Ref: 190997/R Lee
14 Oct 2021

RE: 6/2021/2207/MAJ – Campus West, The Campus, Welwyn Garden City, AL8 6BX

Conisbee have been appointed by Welwyn Hatfield Borough Council (WHBC) to produce a Flood Risk Assessment (FRA) and Drainage Strategy to support a planning application for a new multi-storey decked car park at the site of the existing Campus West Car Park.

This note has been prepared to address comments raised by Hertfordshire County Council (HCC) Lead Local Flood Authority (LLFA) regarding the application, refer to correspondence attached at **Appendix A**.

APPENDIX E – EAS DRAWING 2486-SK04

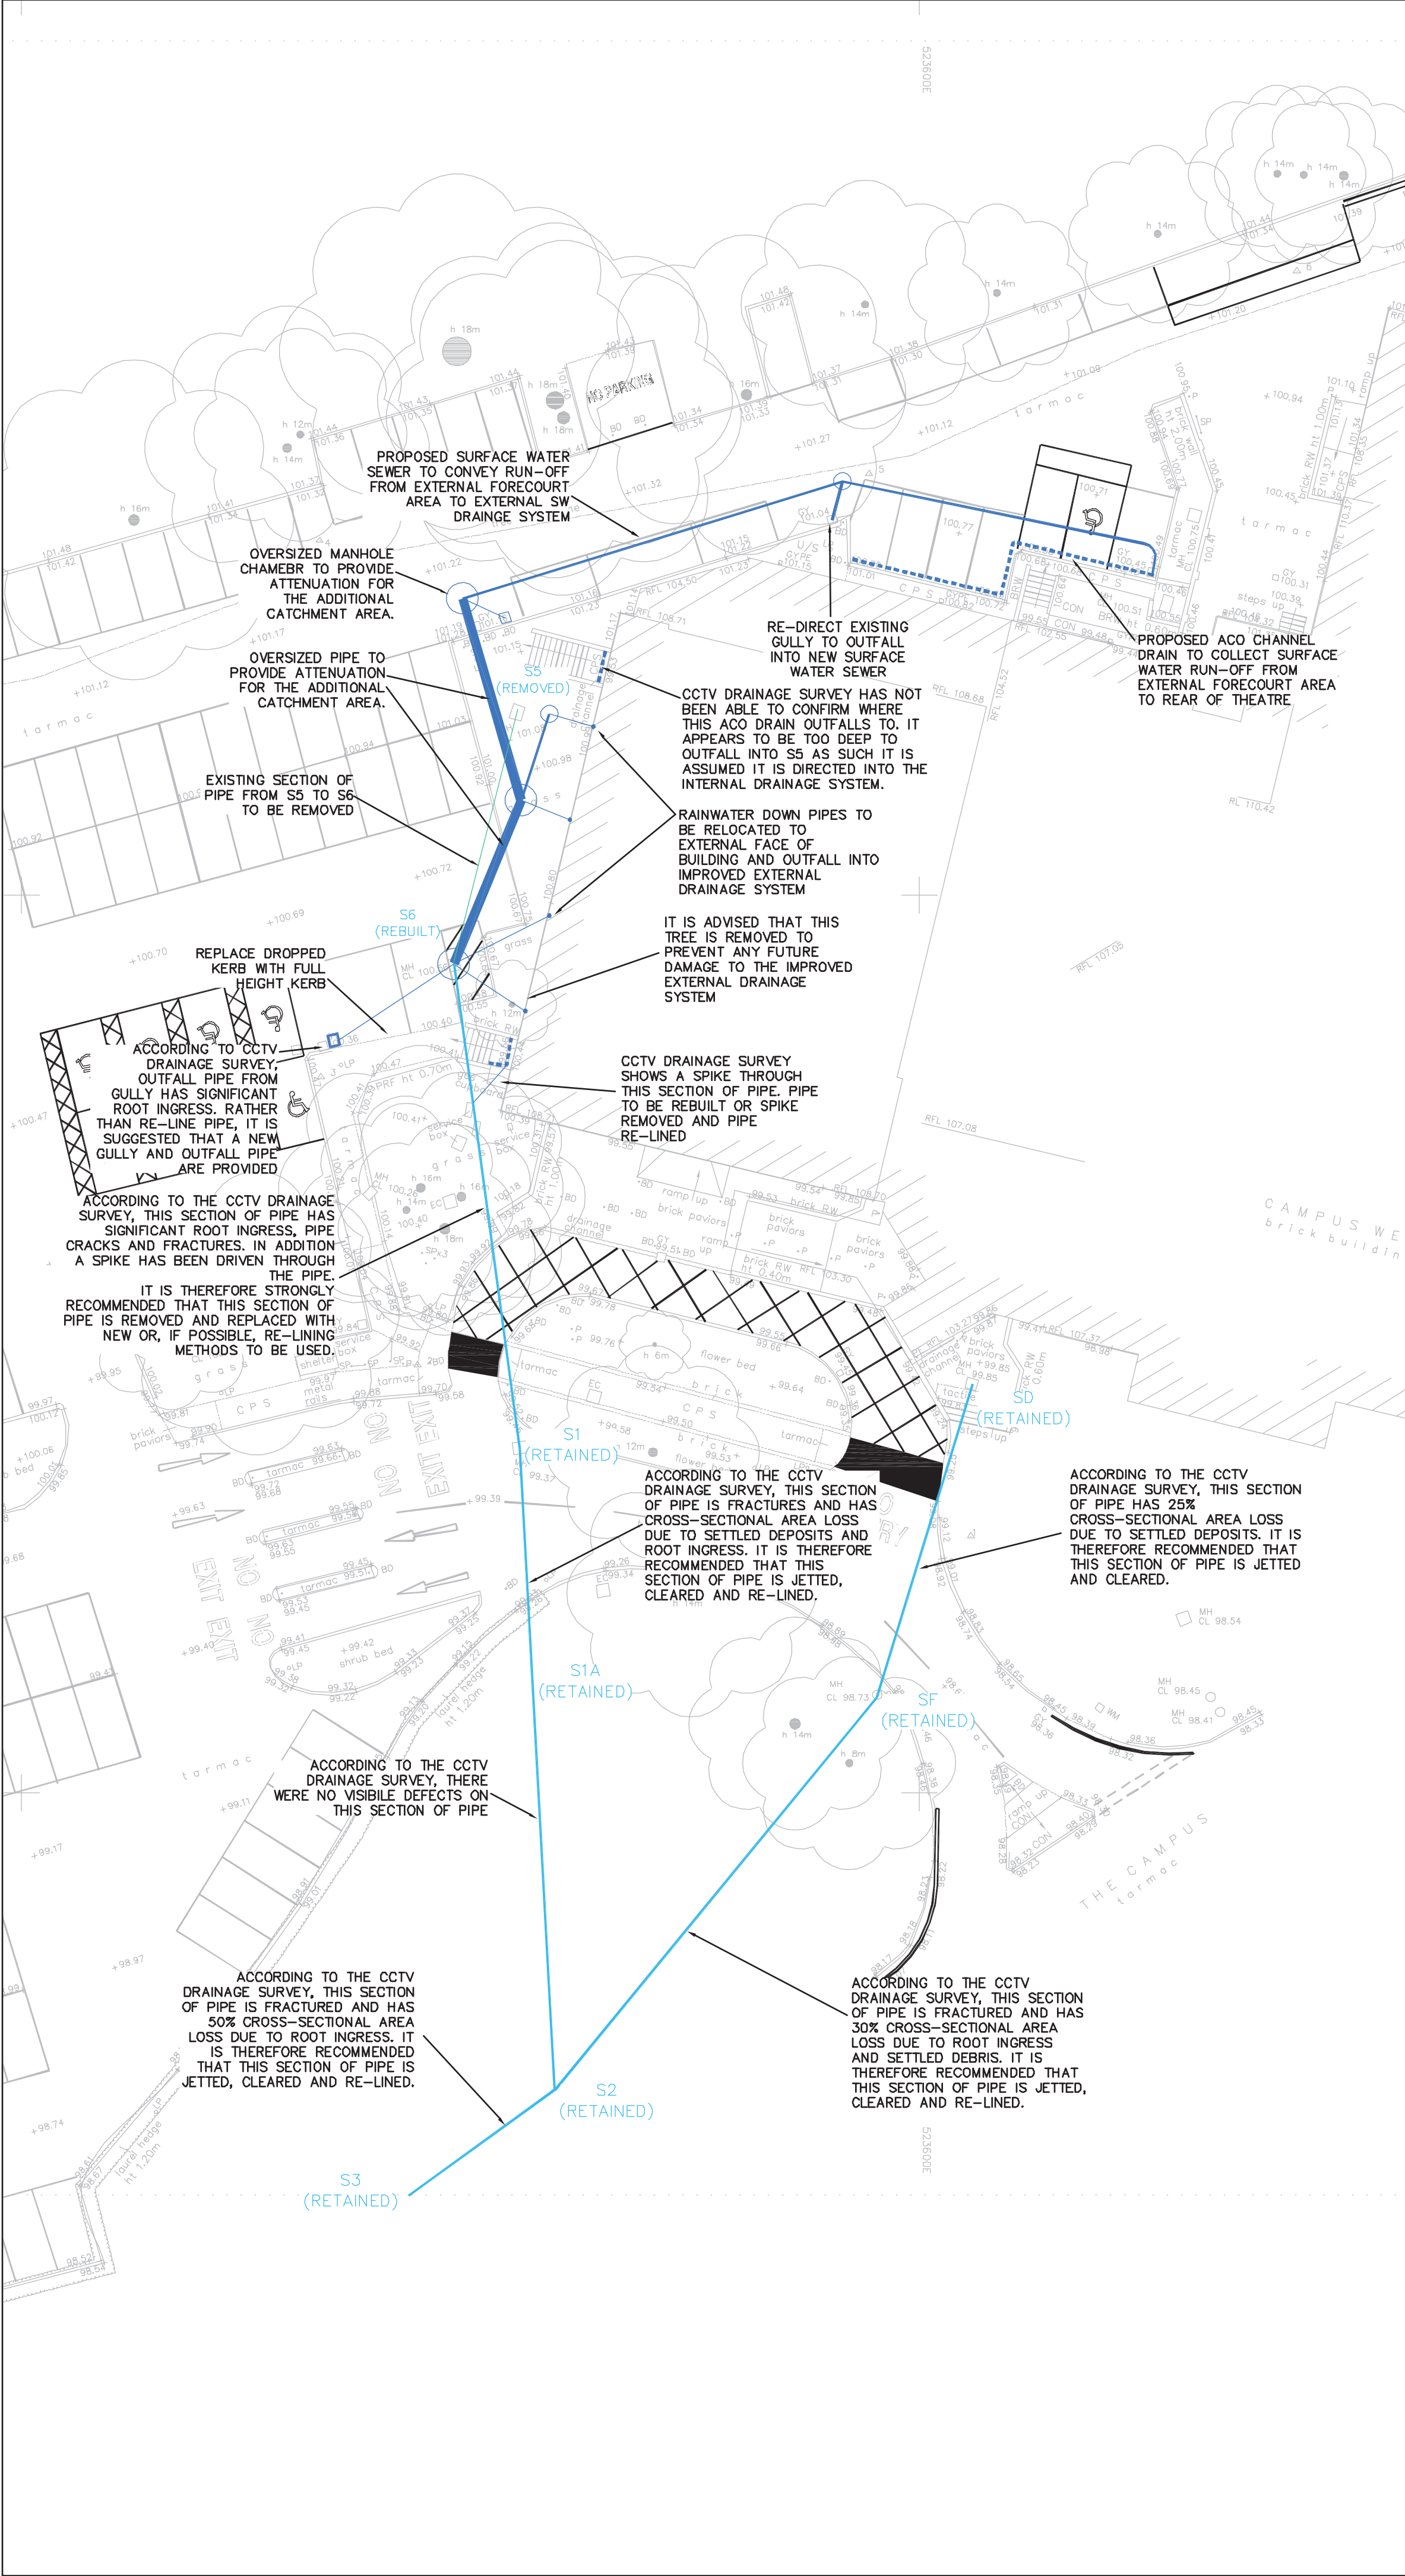
We note that the Drainage Strategy Plan makes reference to an EAS Drawing 2486-SK04 for Details of Proposed Roller City Drainage Improvements Works. If part of the site is to be drained via a separate drainage system, the drawings should be submitted to the LPA.

If there are areas of the site that are proposed to be drained via a separate drainage system, the plans should be submitted to the LPA.

As noted in the submitted FRA & Drainage Strategy Report, works to provide improvements to the existing drainage system serving the Roller City and Campus West Theatre have recently been implemented. Details of these works are included at Appendix E of the submitted report, and as-built drawings are included at **Appendix C** of this note.

APPENDIX F – DRAINAGE STRATEGY

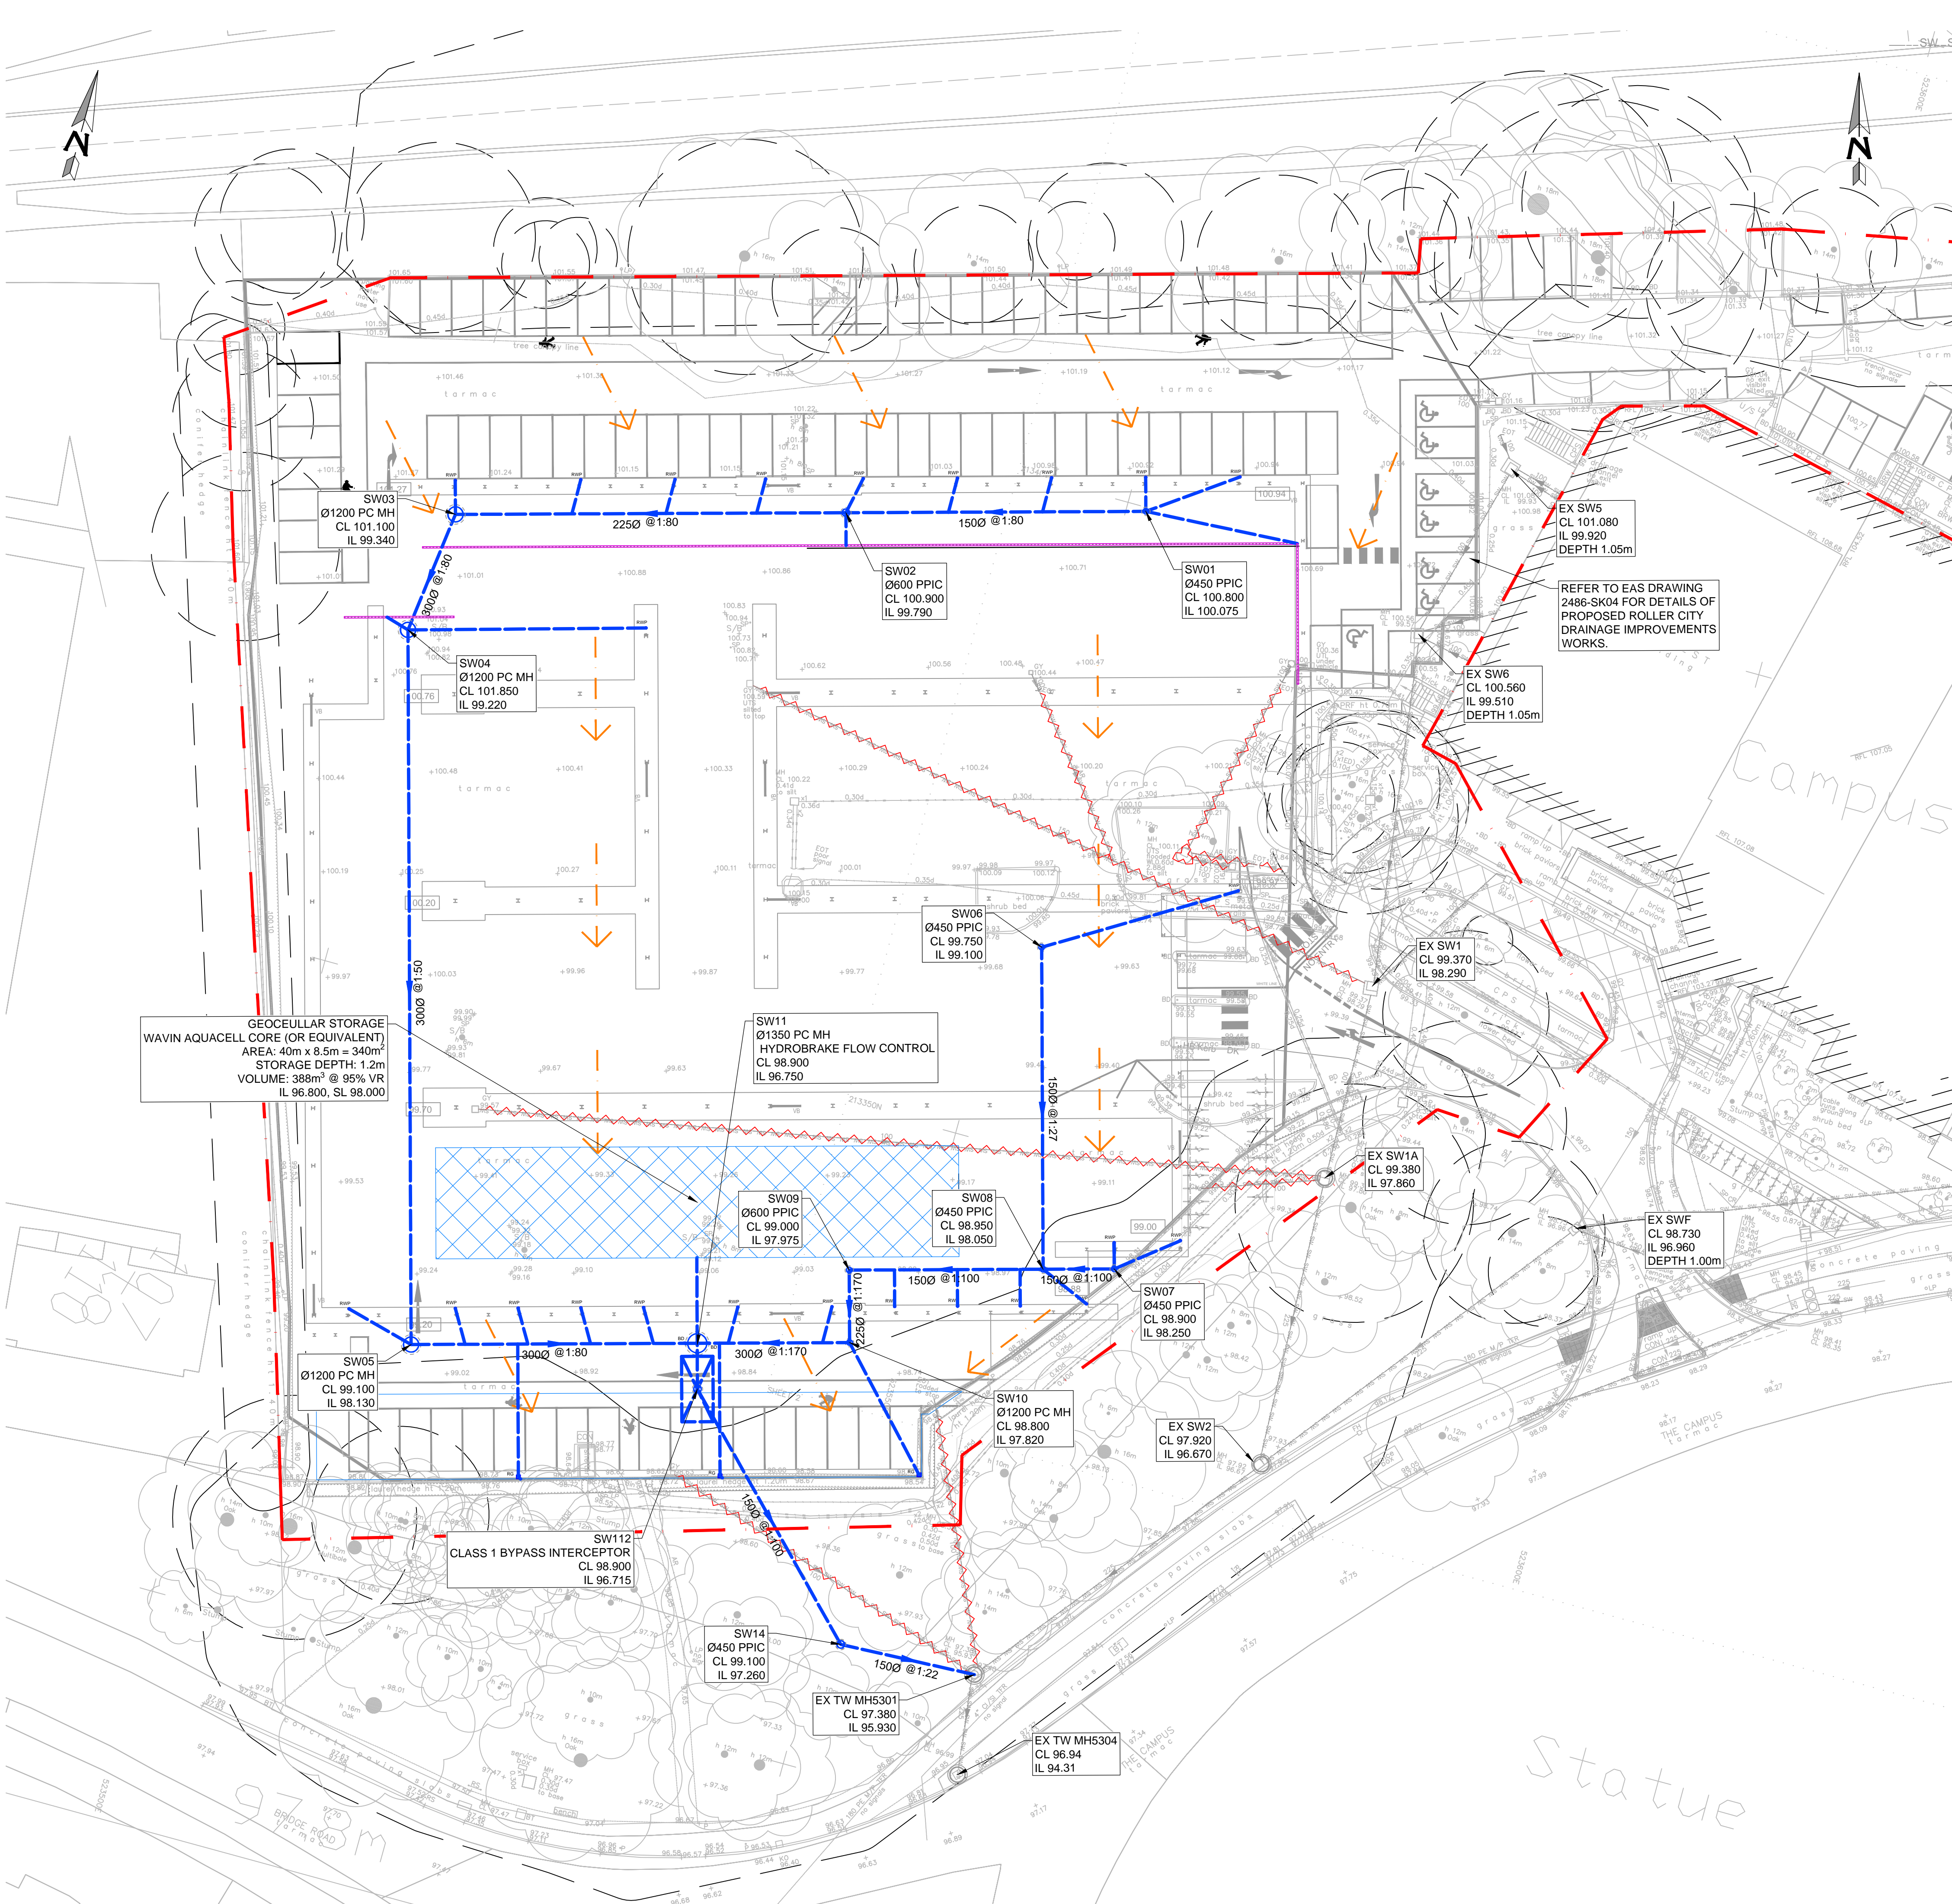
We understand that the site plan has been updated since the Pre-Application stage where the LLFA were consulted. We note there is additional area included in the site layout now and the drainage strategy has not been updated to include the additional area.

The applicant should update the drainage strategy to include the additional site area as we would expect the applicant to actively drain the entire site area. If there is existing site drainage that is to be reused for the additional site area this should be submitted to the LPA.

It is proposed that the existing drainage systems in these areas are retained. GPR survey has been undertaken by Terrain Survey which confirms the layouts of the existing surface water systems in these areas. Refer to drawing TS20-006-4 attached at **Appendix C**.
